Technical Response Note

29 February 2024
Version 1.0
Issue

UTC Modelling Comments

Figure Number:
 Figure 6

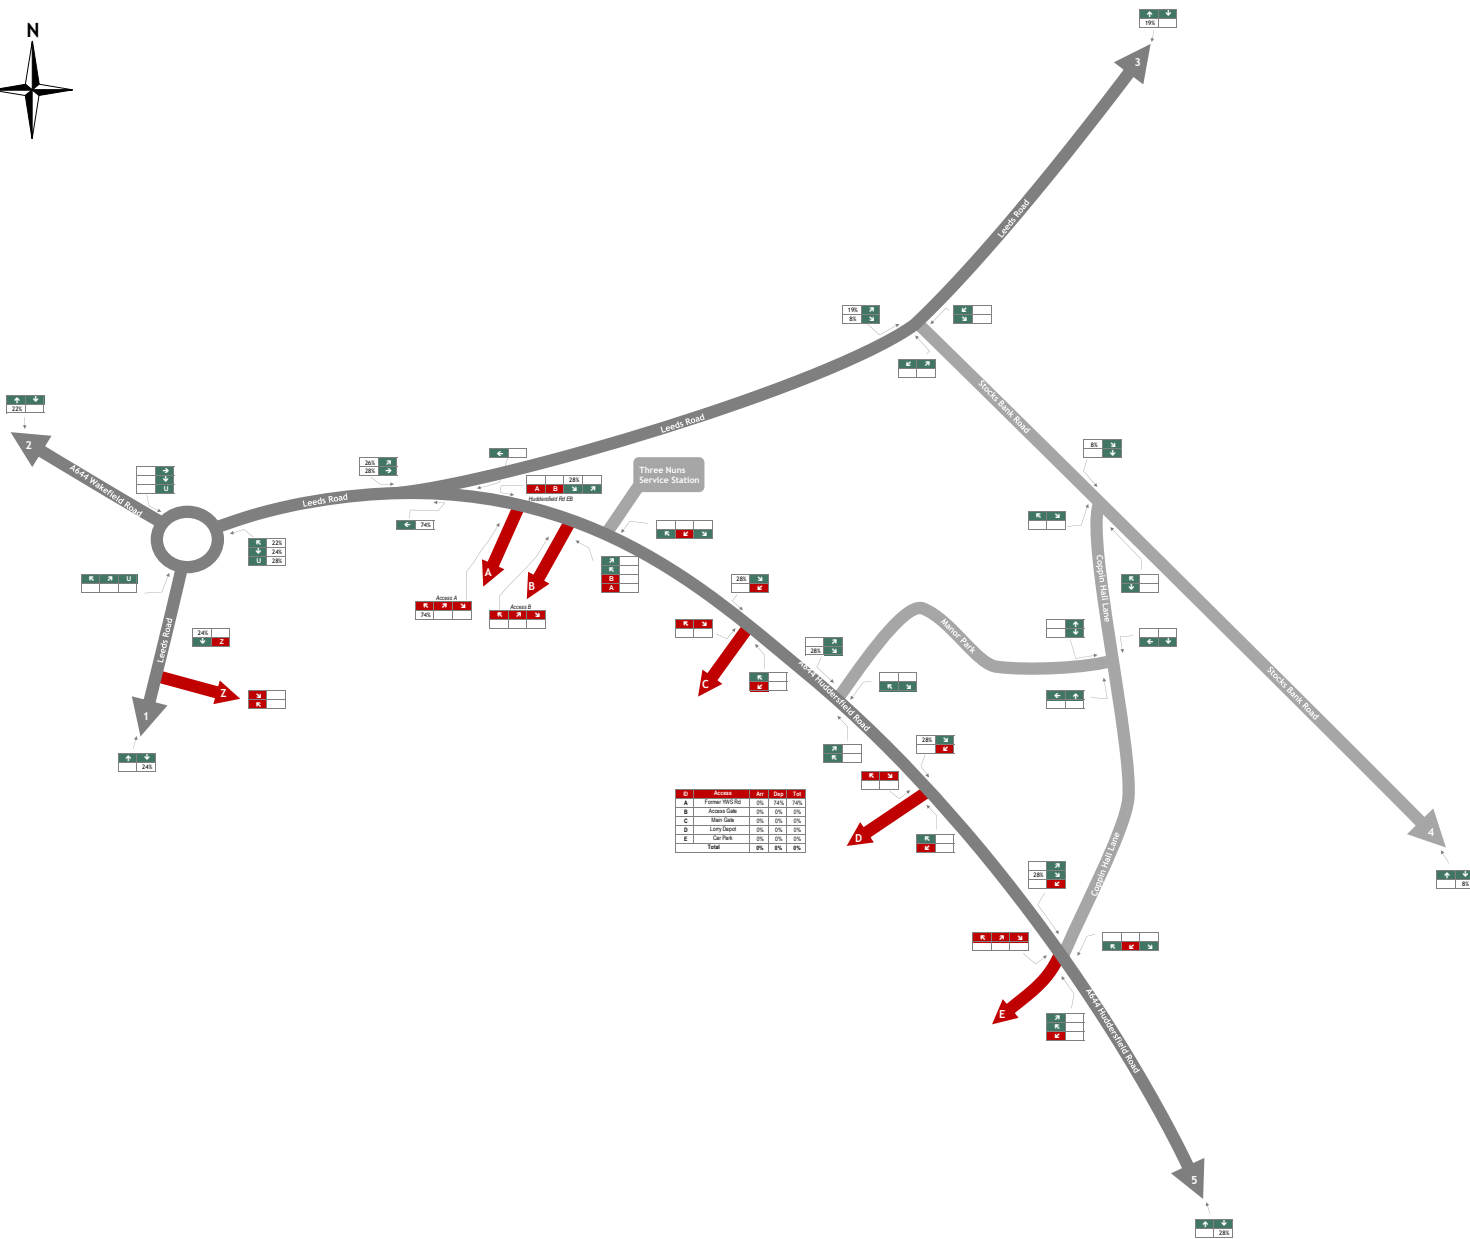
Figure	Fore Comment
6	28% of Light Vehicle trips from Huddersfield Rd (E) now turn left entry into Access A.
7	28% of Light Vehicle to Huddersfield Rd (E) now turn left on exit from Access A and U-turn around the Cooper Bridge roundabout. The 26% of trips to A62 Leeds Rd (E) and Stocks Bank Rd do the same manoeuvre, but travel on A62 Leeds Rd, instead of A644 Huddersfield Rd.
8	No Change.
9	
10	Updated flows based on changes to Figures 6 & 7.
11	
12	No Change.
13	
14	
15	
16	HGV trips now turn left on exit from Access A and U-turn around the Cooper Bridge roundabout, before travelling on A644 Huddersfield Rd (E) and into Access C. No scope to internalise trips. Boxes to include traffic on entry / egress of Access Z included.
17	
18	Updated flows based on changes to Figure 16. Boxes to include traffic on entry / egress of Access Z included.
19	Updated flows based on changes to Figure 17. Boxes to include traffic on entry / egress of Access Z included.

Scale: Not to scale | Figure Status: Issue
 Job Number: 3633 | Figure Number: Figure 20

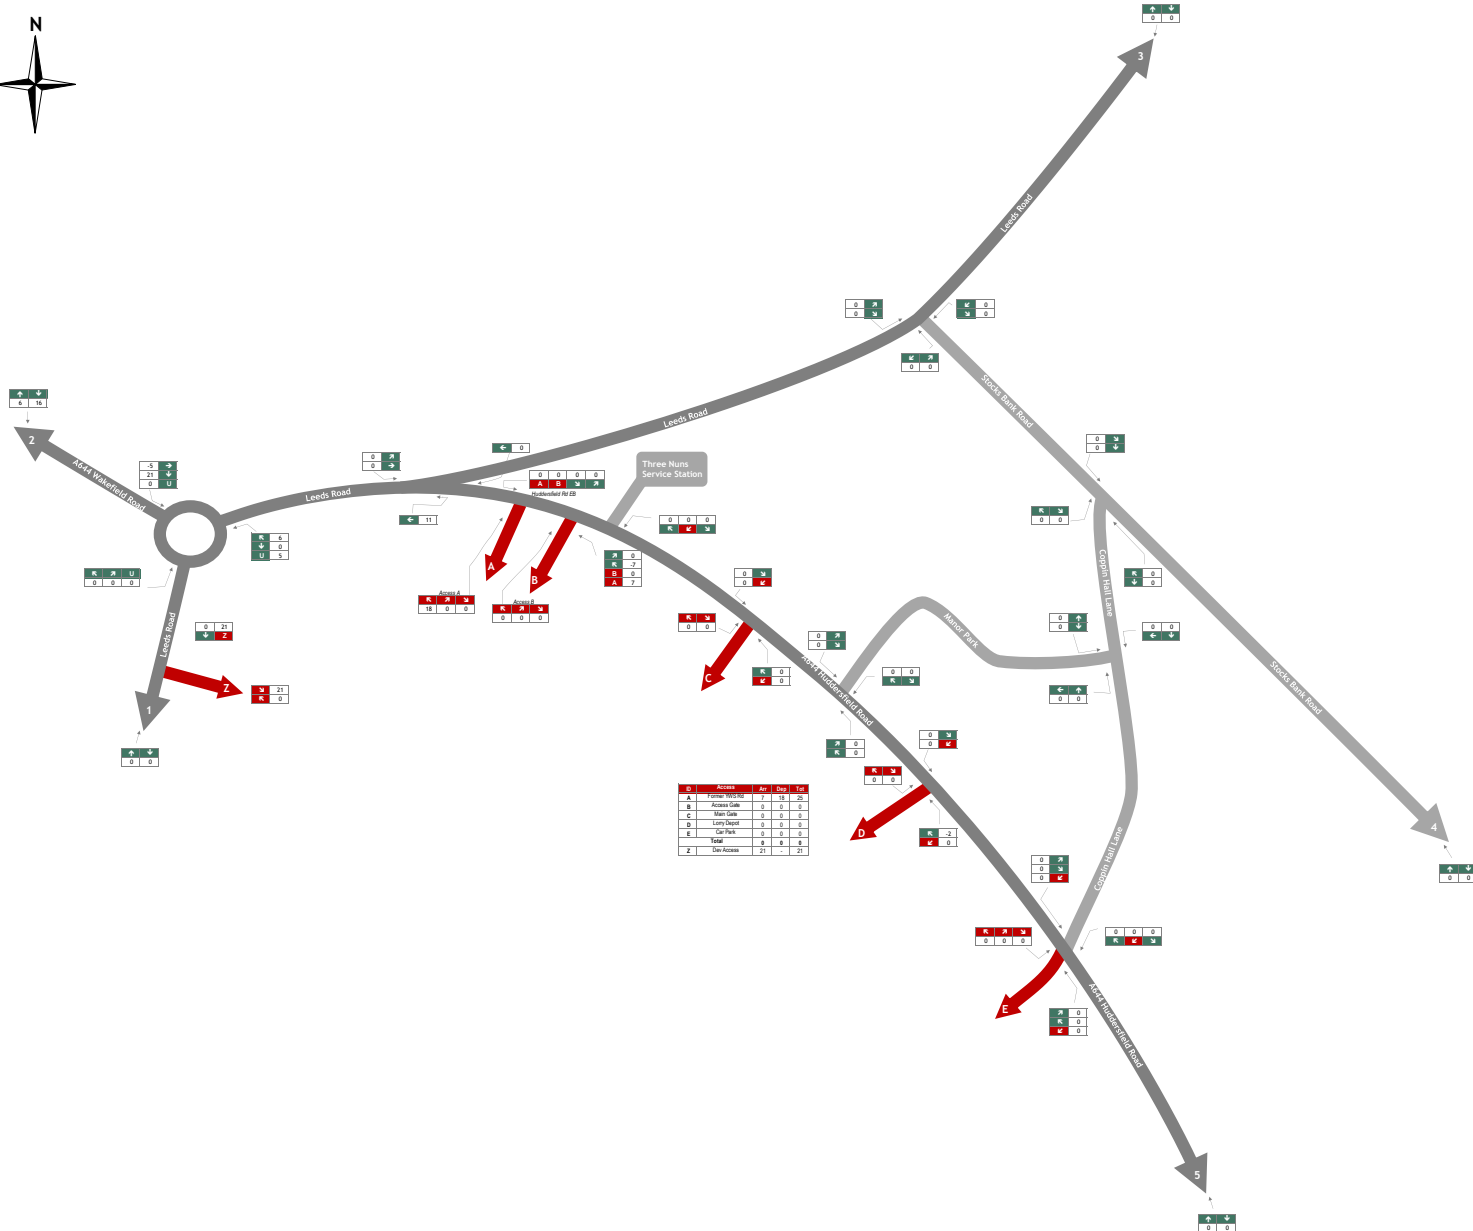
20	Updated flows based on changes to Figure 16.
21	Updated flows based on changes to Figure 17.
22	Updated flows based on traffic flow changes to Figures 10 & 20.
23	Updated flows based on traffic flow changes to Figures 11 & 21.
24	Updated flows based on traffic flow changes to Figures 10 & 20.
25	Updated flows based on traffic flow changes to Figures 11 & 21.
